# CITY OF ALBUQUERQUE

**Re: Red Rock Roasters 4801 Jefferson St NE**  
**Grading and Drainage Plan**  
**Engineer's Stamp date 9-24-12 (F-17/D096)**

Based upon the information provided in your submittal received 9-26-12, the above referenced plan cannot be approved for Building Permit or Grading Permit until the following comments are addressed:

SHEET No. **C1**

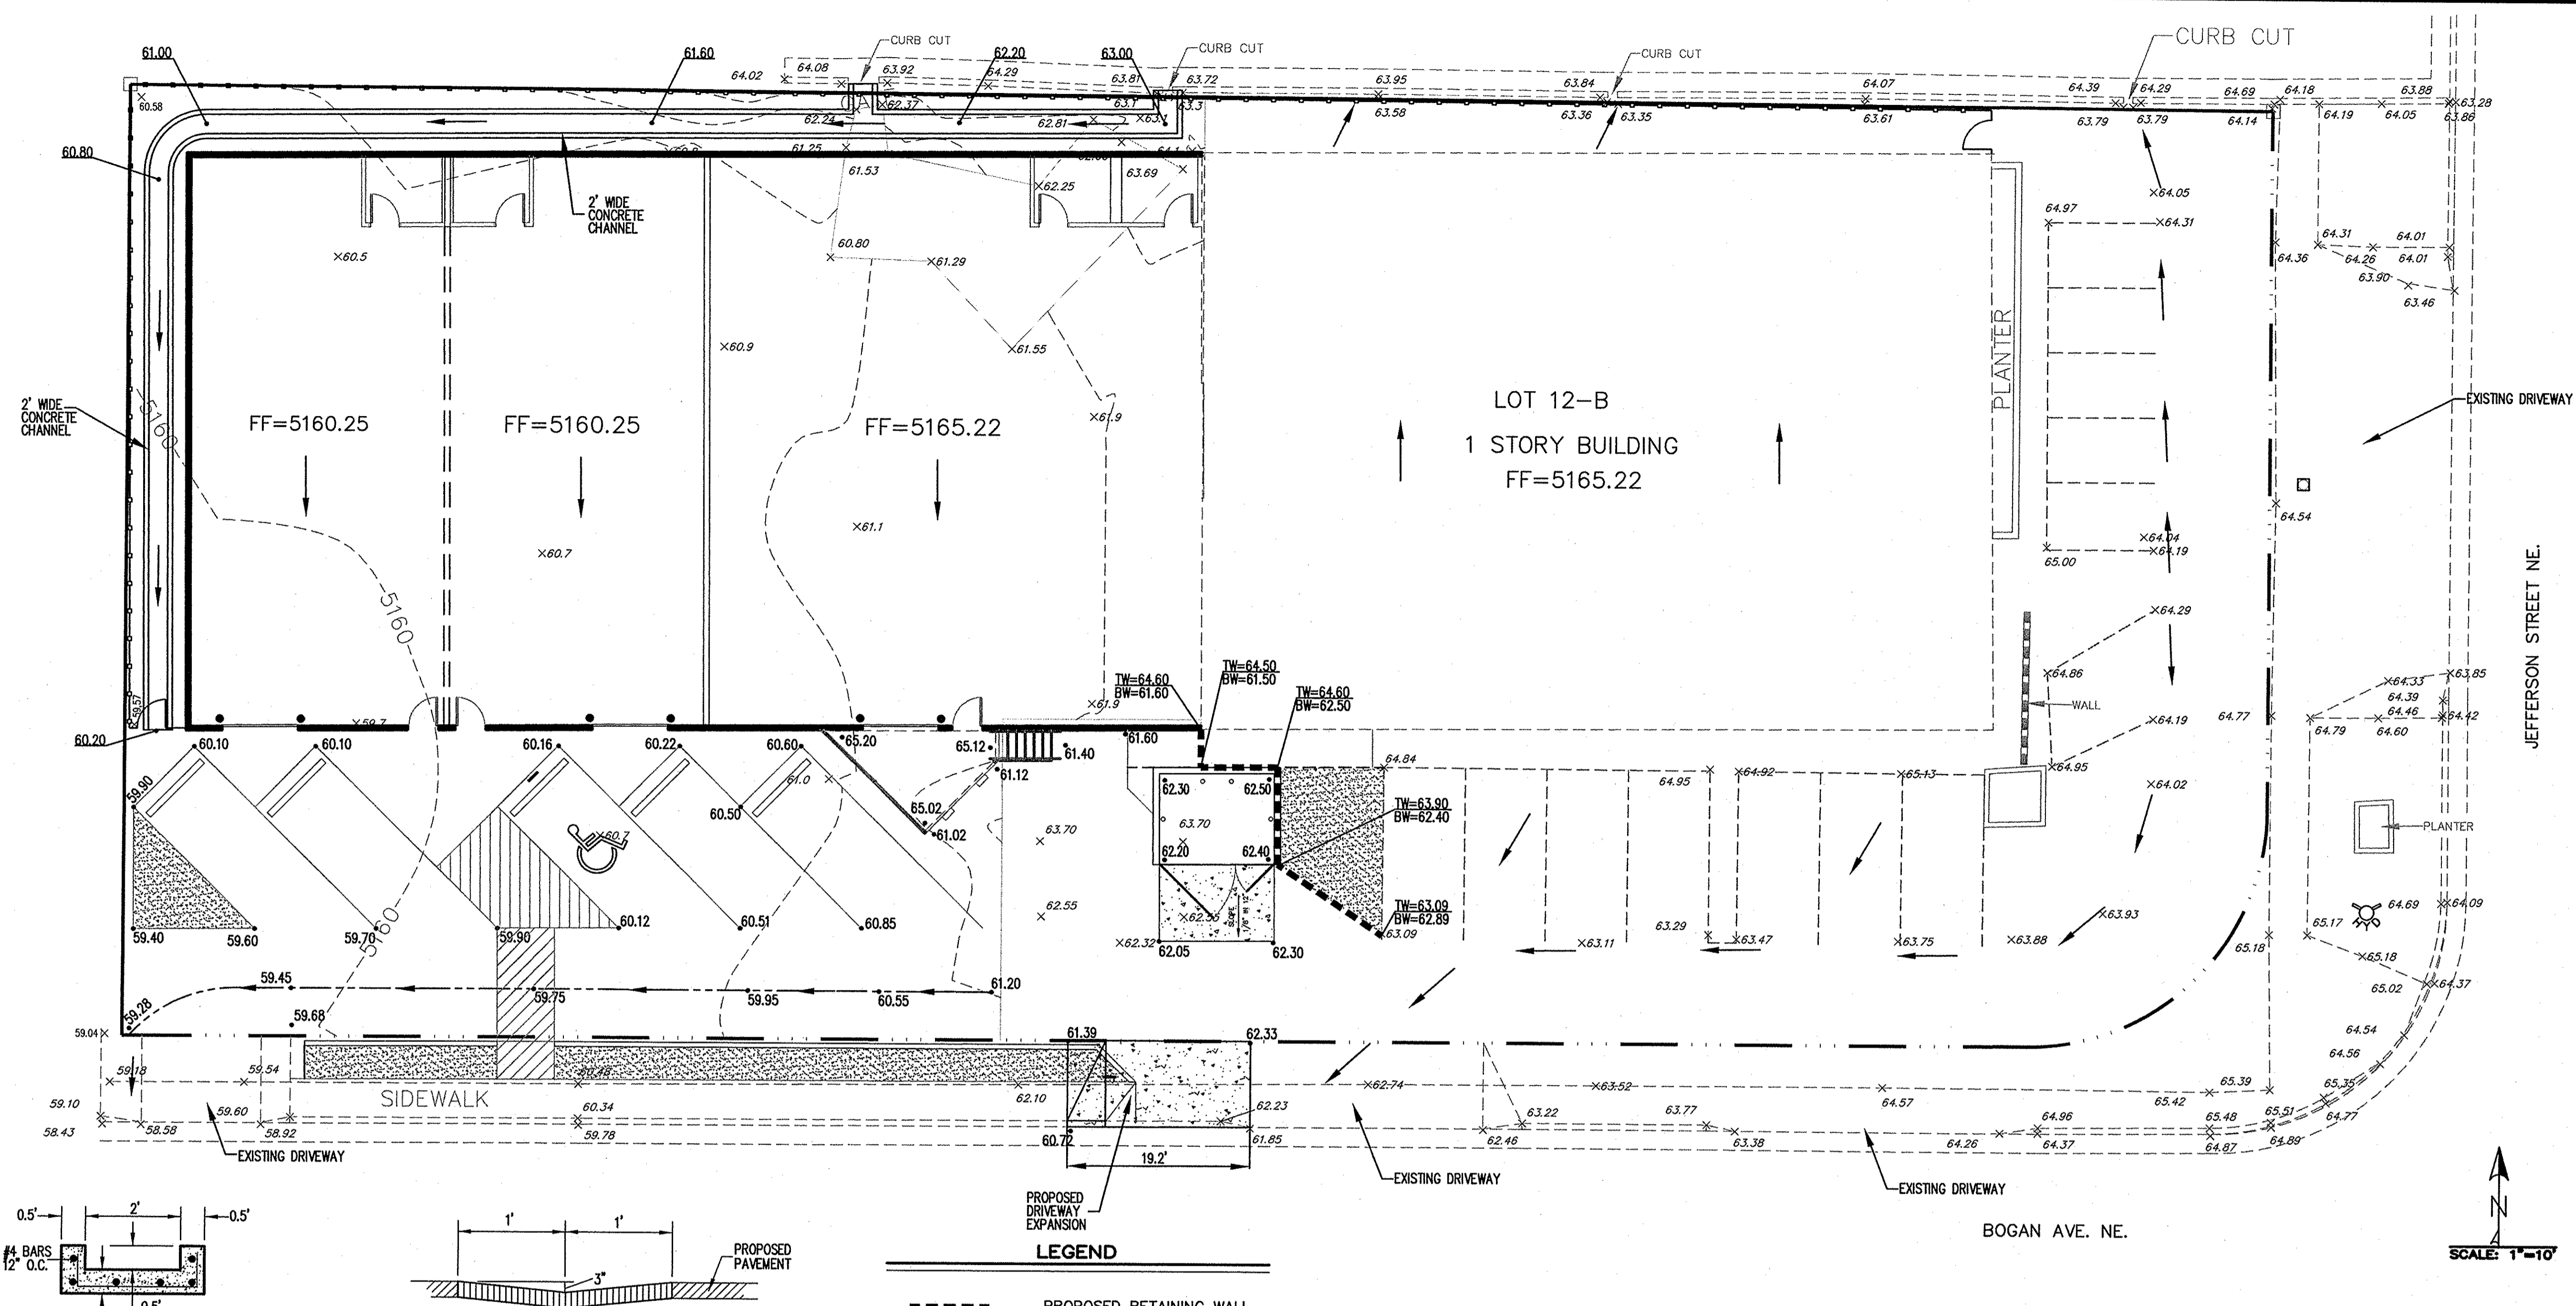
- Indicate the direction of roof flows on the plan.
- Provide details of the proposed swale indicated in the legend.
- Provide spot elevations along the west end of property.
- An agreement for the curb cuts and cross drainage is needed.
- Are the speckled areas landscaping?
- All landscaped areas need to be depressed?

I spoke with zoning about this plan because of the lack of landscaping. Judging from this plan it is believed that not enough landscaping has been provided. Contact David Kilpatrick at 924-3838 for a better idea of how much landscaping will be needed for this site. I believe that the G&D plan may change.
